# CITY OF ALBUQUERQUE

April 7, 2021

**Re: Insight Construction**  
**3821 12<sup>th</sup> Street NW**  
**Traffic Circulation Layout**  
Engineer's 11-24-2020 (G14-D096)

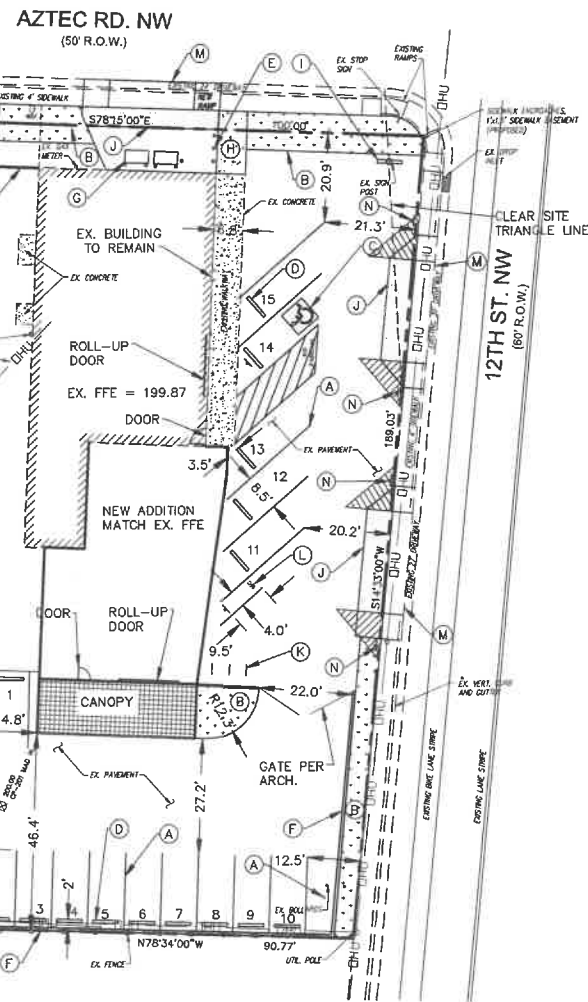
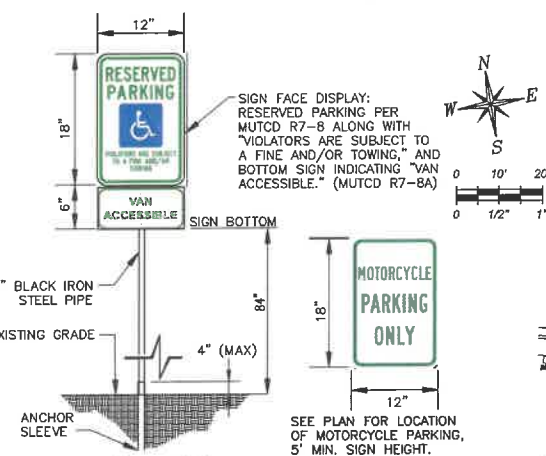
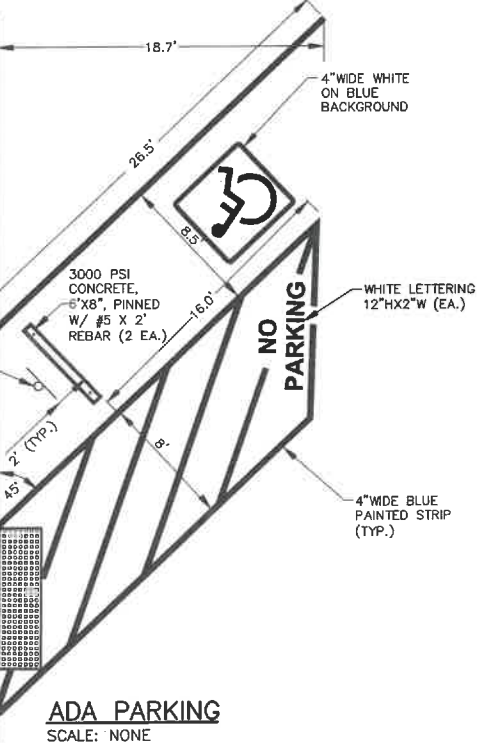
1. List the number of parking spaces required by the IDO as well as the proposed number of parking spaces including bicycle and motorcycle parking and **discuss with Zoning**.
2. Please identify all existing buildings, **doors**, structures, sidewalks, curbs, **drive pads**, wall and **anything that influences the parking and circulation on the site**.
3. The Location Map needs to read G-14 and not G-13. Please address.
4. Identify all existing access easements (**IF APPLICABLE**).
5. Aztec Road and 12<sup>th</sup> Street existing driveways will need to be current ADA accessible. Please modify these driveways (**DISCUSS THIS REQUIREMENT**).
6. Maximum access width for arterial (**12<sup>th</sup> St**), collector, and local streets are as follows:
- 7.

8. Provide concrete design and detail on TCL which has been reference on the Grading and drainage sheets (**Key note H**).

9. Any private structures that are located within public right-of-way such as fences and walls shall either be removed or else a revocable permit with the City is required in which an annual fee is paid per year, based on square footage of the encroachment. **Key note I, existing sign appears to be in the public Row in accordance to AGIS. Please verify the exact Property line location.** Due to sight distance concerns and to construct sufficient curb ramps, right-of-way dedication is required to add curves to corners of properties at intersections if they are not already developed. See Table 23.3 of the DPM.
10. **The minimum parking stall dimensions are:**

11. The ADA accessible spaces must include an access aisle. **Van accessible aisles should be 8ft wide**; all others should be 5ft wide.
12. The ADA accessible parking sign: You reference MUTCD for the minimum sign height, **please verify what MUTCD requirements.**

13. **ADA curb ramps must be updated to current standards and have truncated domes installed on public street corner of Aztec Road and 12<sup>th</sup> St NW.**

14. Motorcycle parking space: **Label pavement MC. You will need to show the location of proposed sign. It is not shown on the layout portion of your site plan.**

15. **All bicycle racks shall be designed according to the following guidelines:**
- The rack shall be a minimum 30 inches tall and 18 inches wide.**
  - The bicycle frame shall be supported horizontally at two or more places. Comb/toaster racks are not allowed.**

16. **Bicycle racks shall be sturdy and anchored to a concrete pad.**
17. **A 1-foot clear zone around the bicycle parking stall shall be provided.**
18. **Bicycle parking spaces shall be at least 6 feet long and 2 feet wide.**

19. Proposed bike rack locations shall not interfere with **the 6ft ADA requirements.**
20. The minimum drive aisle dimensions are shown below

**## Your drive aisle at the proposed gate 16 ft needs to be 22 ft and 20.3 ft.**

21. List radii for all curves shown; for passenger vehicles. Radius for delivery trucks, fire trucks, etc. is 25 ft. or larger. **Please coordinate with FD on this concern.**

22. Per the IDO, a **6 ft. wide ADA accessible pedestrian pathway is required from the public sidewalk to the building entrances.** Please clearly show this pathway and provide details and widths. **The existing sign should not interfere with the pathway.**

23. Per DPM, a **6 ft. wide ADA accessible pedestrian pathway is required from the ADA parking stall access aisles to the building entrances.** Please clearly show this pathway and provide details and widths.

24. All sidewalks along streets (12<sup>th</sup> Street): **Provide the existing width and make sure you sidewalk connection doesn't interfere with existing ADA ramp on public street.**

25. The parking barrier curb should follow the **2 ft overhang requirements** and not interfere with the 6ft ADA pathway (building frontage) and proposed wall on the proposed southern parking (Key note I & H).

26. Refuse vehicle maneuvering shall be contained on-site. **The refuse vehicle shall not back into the public right of way** and provide the exact width that refuse vehicle will have to maneuver of Aztec Road. **Provide a copy of refuse approval.**

27. Key E and bollards detail: **Paint all bollards traffic yellow.**
28. Key H: Is the proposed sidewalk raised or even with the existing parking lot pavement

29. **Show the clear sight triangle and add the following note to the plan: "Landscaping and signage will not interfere with clear sight requirements. Therefore, signs, walls, trees, and shrubbery between 3 and 8 feet tall (as measured from the gutter pan) will not be acceptable in the clear sight triangle.**

30. **Please specify the City Standard Drawing Number when applicable.**
31. **Unused curb cuts must be replaced with sidewalk and curb & gutter. A build note must be provided referring to the appropriate City Standard drawing (2430 & 2415).**
